**Brett's Aggregates Ltd (Brett)
&
Esso London to Southampton Pipeline**

**Representation 1 – Brett Planning Permission to Extract Sand & Gravel from
Manor Farm and Convey beneath Ashford Road into Queen Mary Quarry,
Ashford Road, Staines**

Drawing number:
B2325300-JAC-000-ENV-DRG-111166

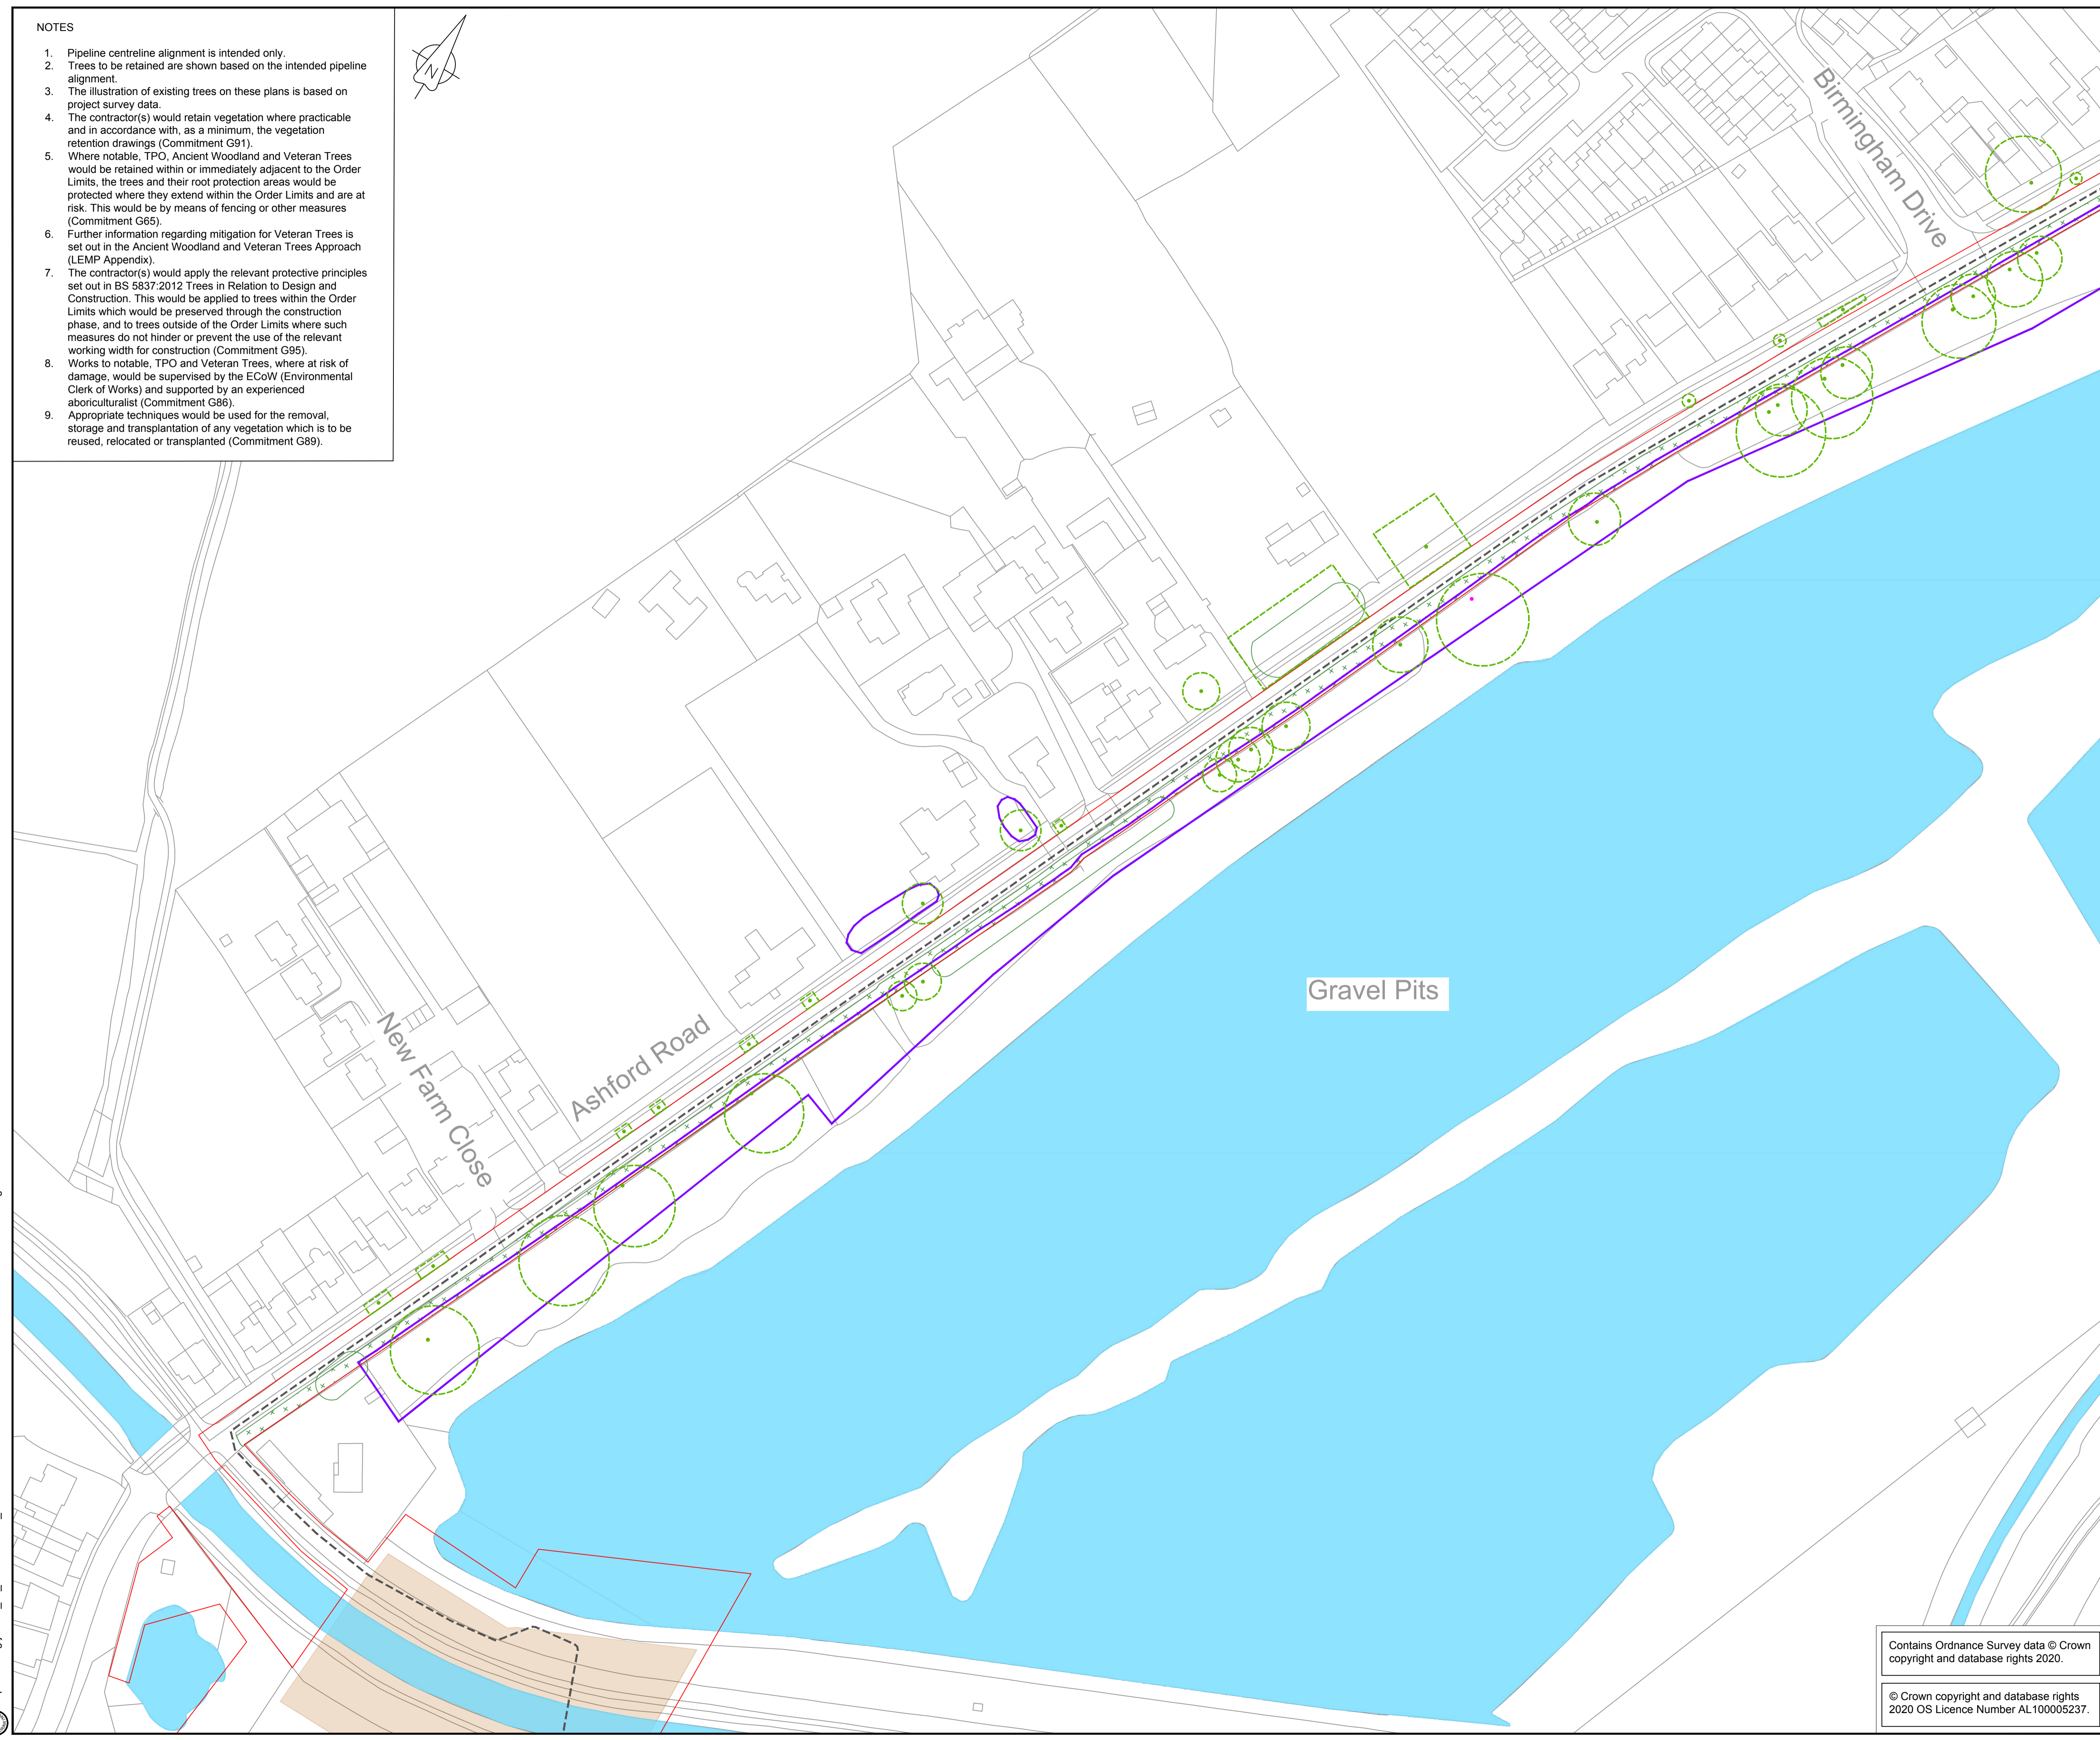
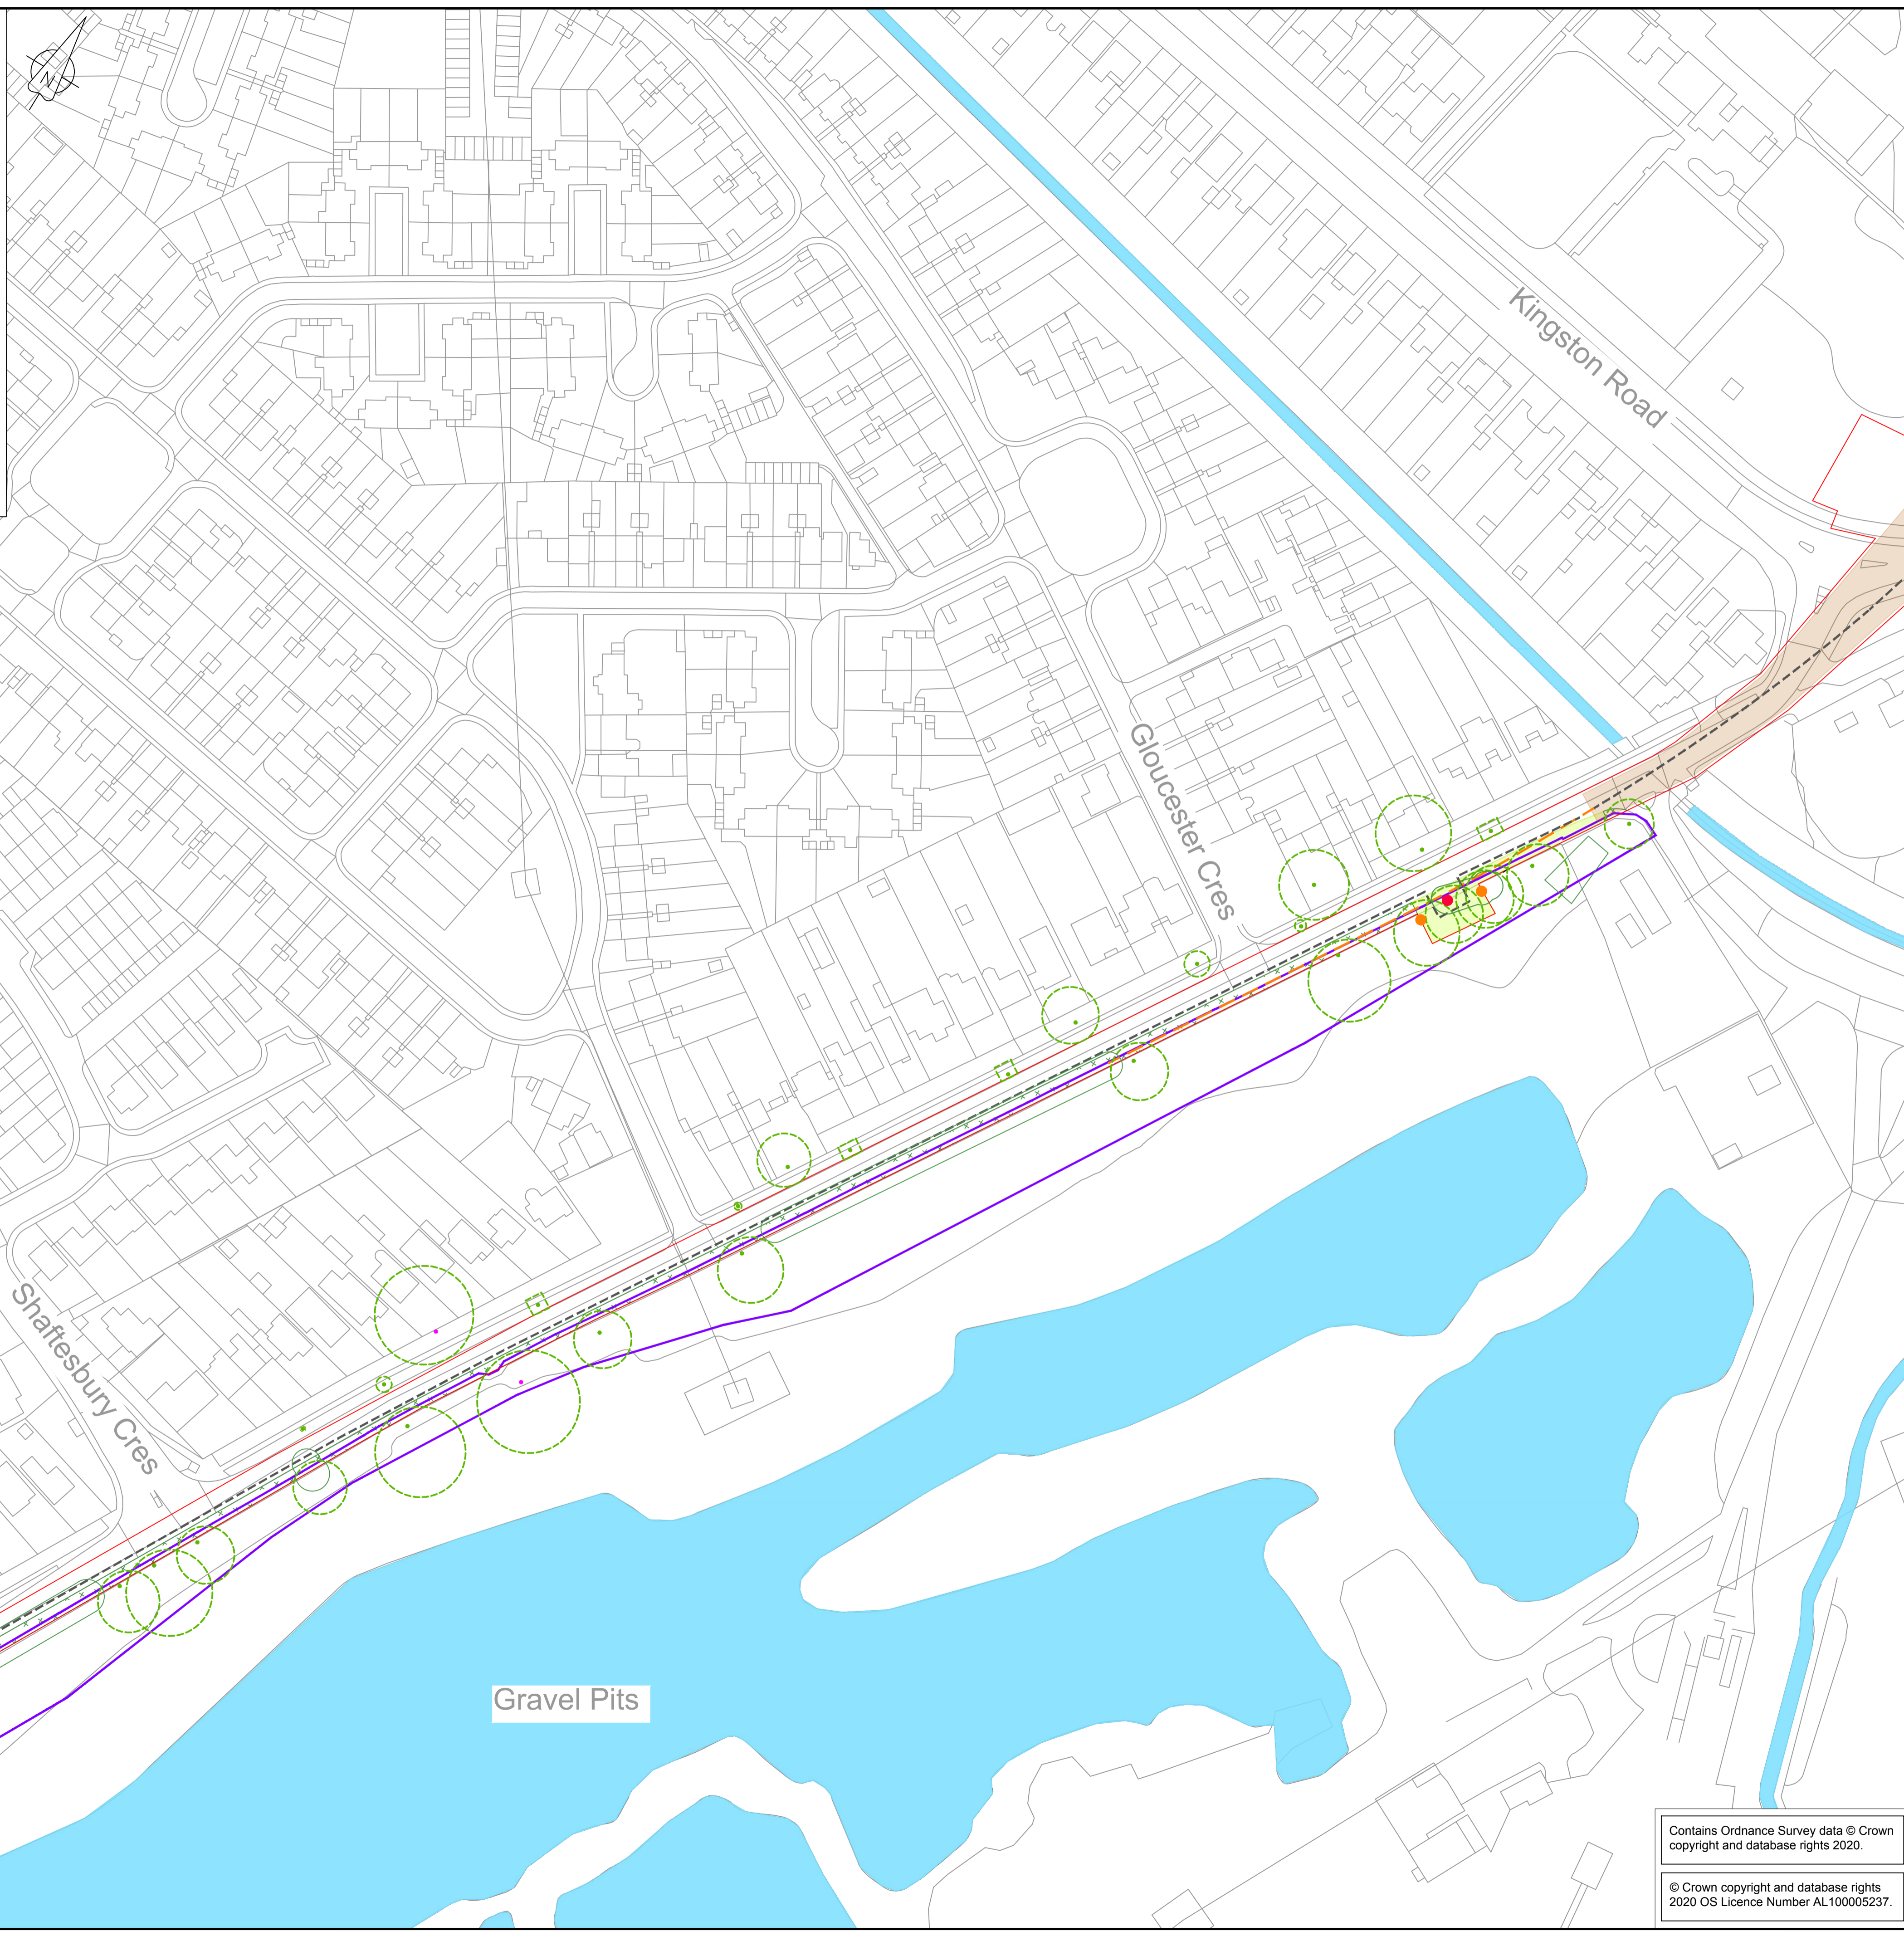
- The general arrangement of the proposed tunnel will run directly beneath the proposed Esso fuel pipeline.
- There is no apparent provision made by Esso for the installation of the conveyor belt tunnel once the proposed fuel pipeline has been put in place along this section of the B377 Ashford Road.

- The installation of the new conveyor belt tunnel is not planned until extraction from Manor Farm commences. It is understood that Esso require to install their new fuel pipeline in the next 2 years. It is essential that the Esso pipeline does not hamper Brett when they come to install their conveyor tunnel. Their DCO application does not demonstrate how this will be achieved.

- Given that Brett have secured all the legal rights to install its proposed conveyor tunnel, prior to Esso's fuel pipeline being proposed, we require Esso to make provision for the installation of the Brett tunnel by entering into a legal agreement ensuring Brett's rights are fully maintained in the future and so not to prevent the abstraction of minerals from this site
